11/2/15

Wheatley CU-15-00003

# Plat Plan Daycare Facility For Toni Stroescher

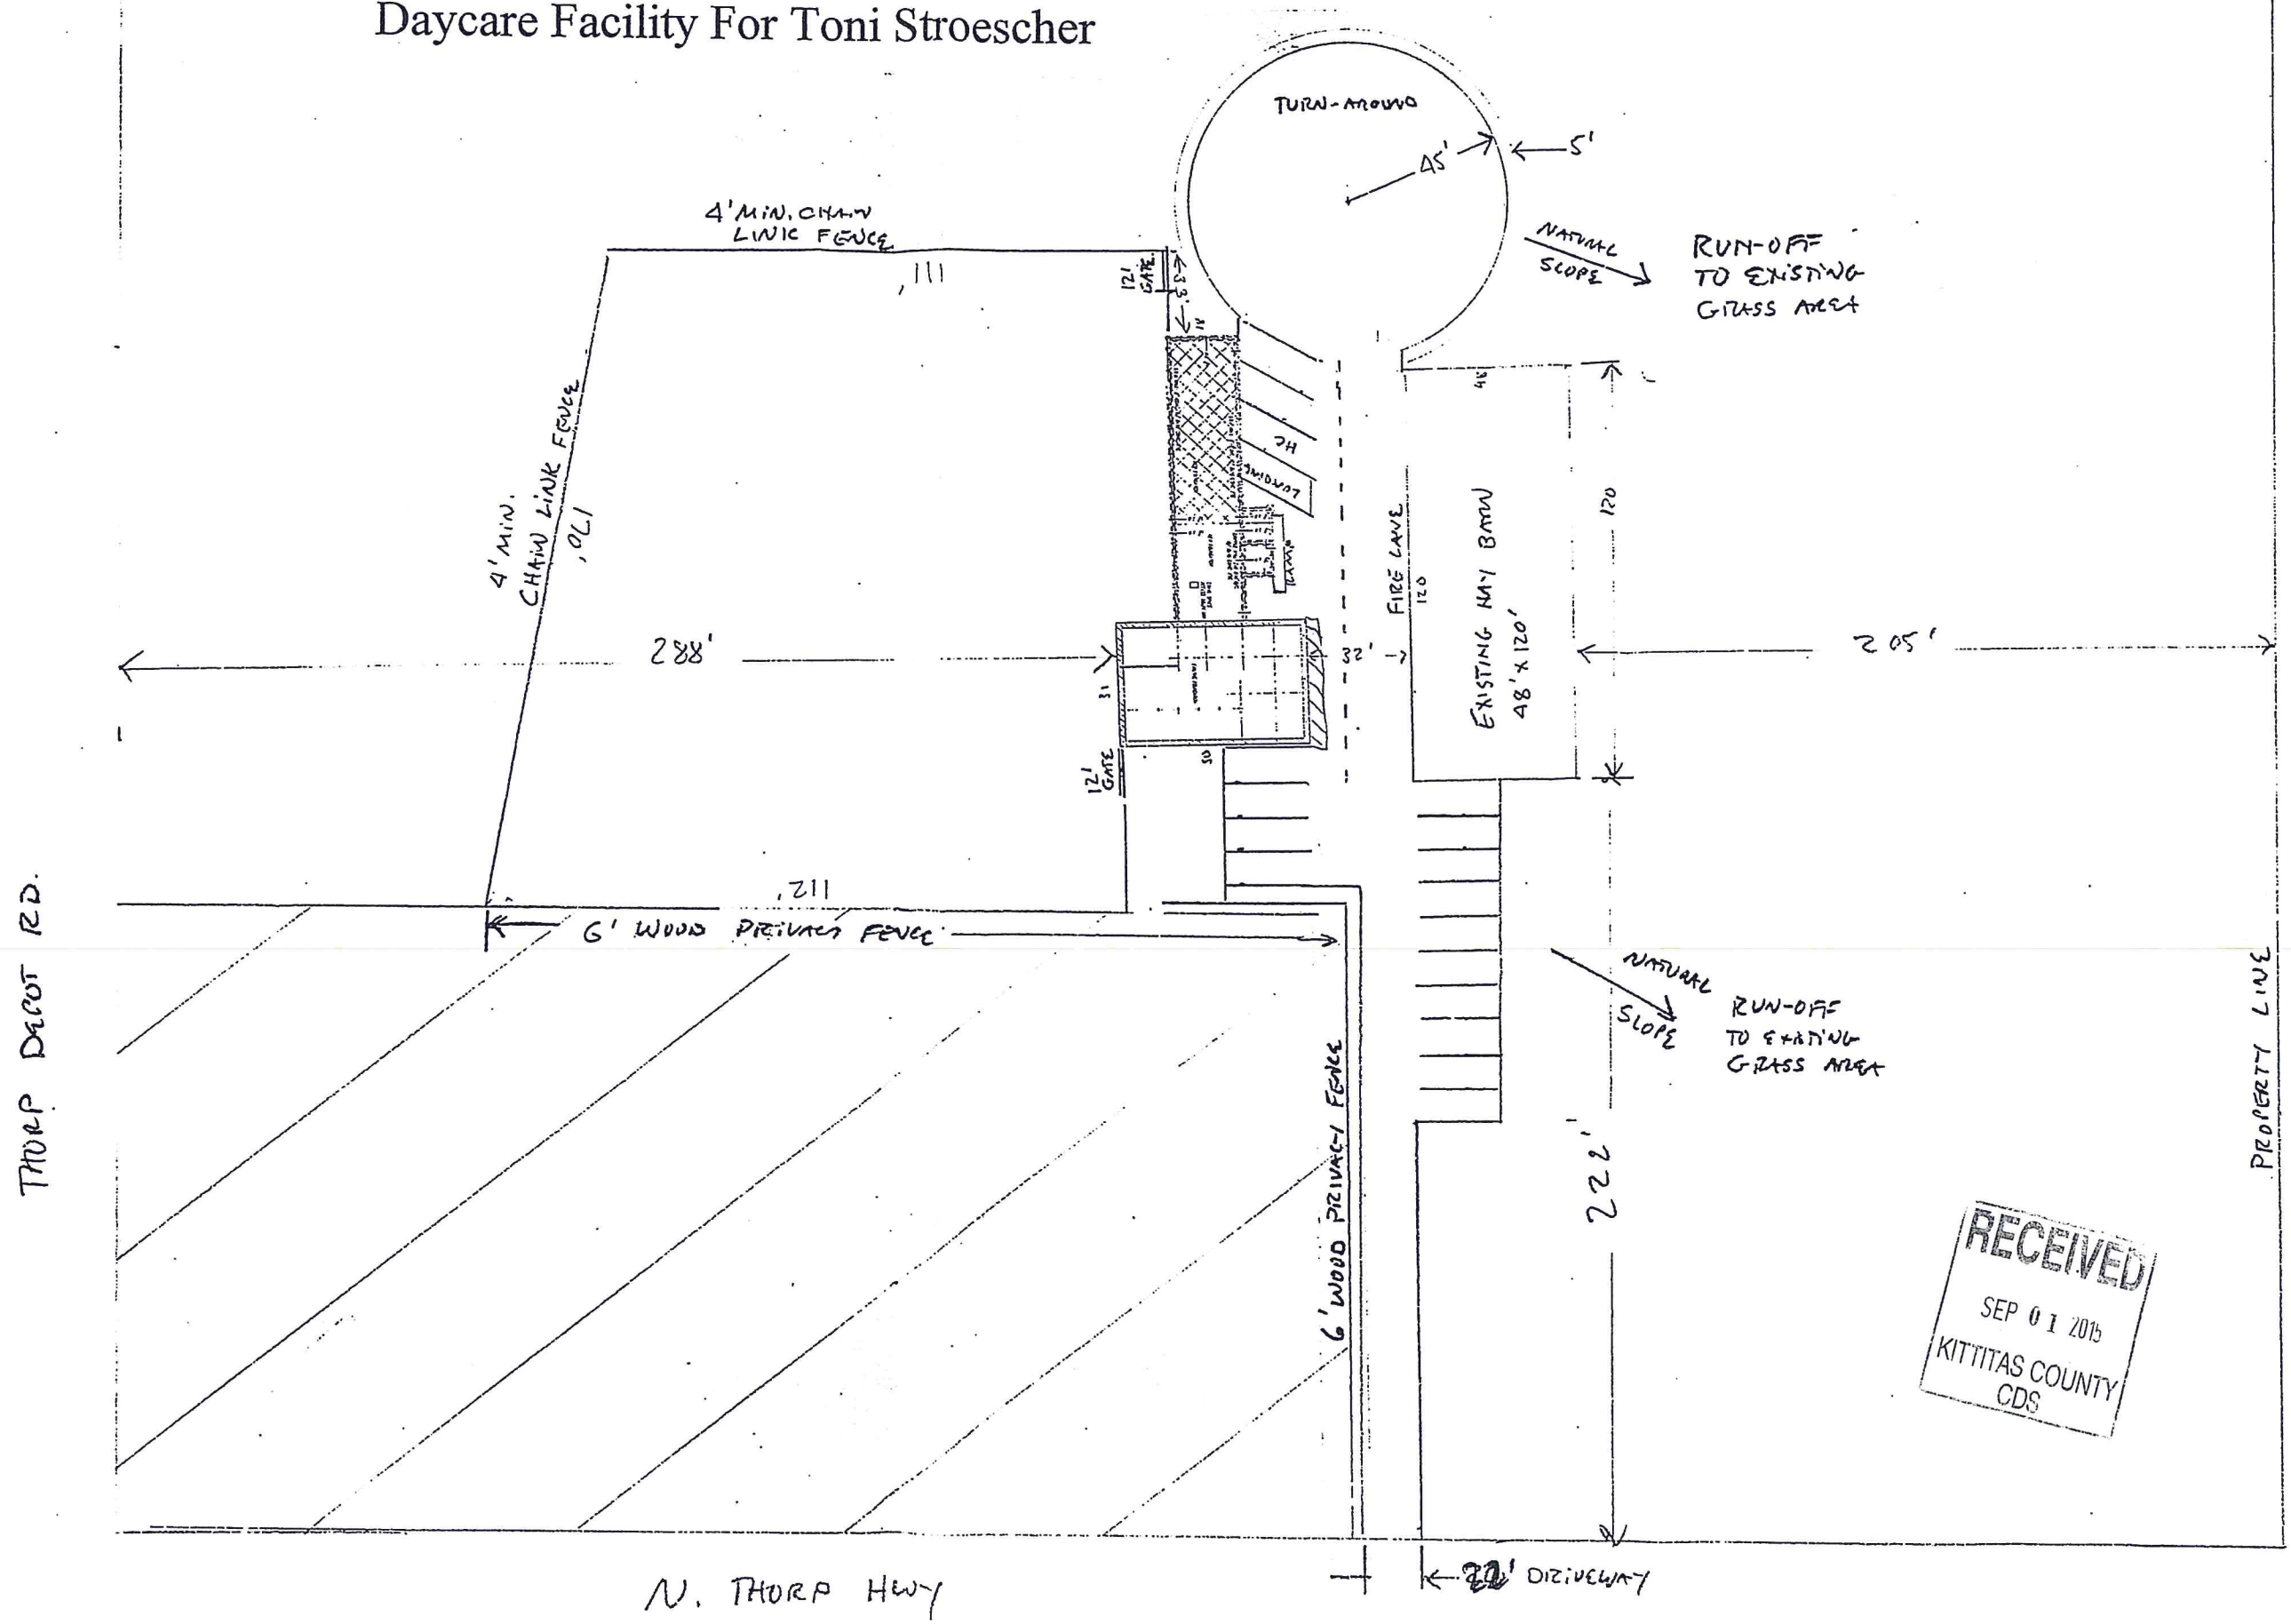
Stormwater would run off through the development property and onto adjacent property and into a drainage ditch that runs water all year. This ditch runs to the Yakima River. This should be a real concern for all users of the water of the Yakima River.

With asphalt parking for customers and employees the potential for fuel, antifreeze, herbicides, and pesticides contaminating run off; ground + surface water is a real concern.

In the SEPA (3)(a) 1 there are 2 ponds east of the Thorp Hwy, in the Gibson gravel pit, across the Hwy from this property. The drainage ditch is approx. 60' north of this property. This should be a real concern for stormwater run off. All are closer than mile from this project.
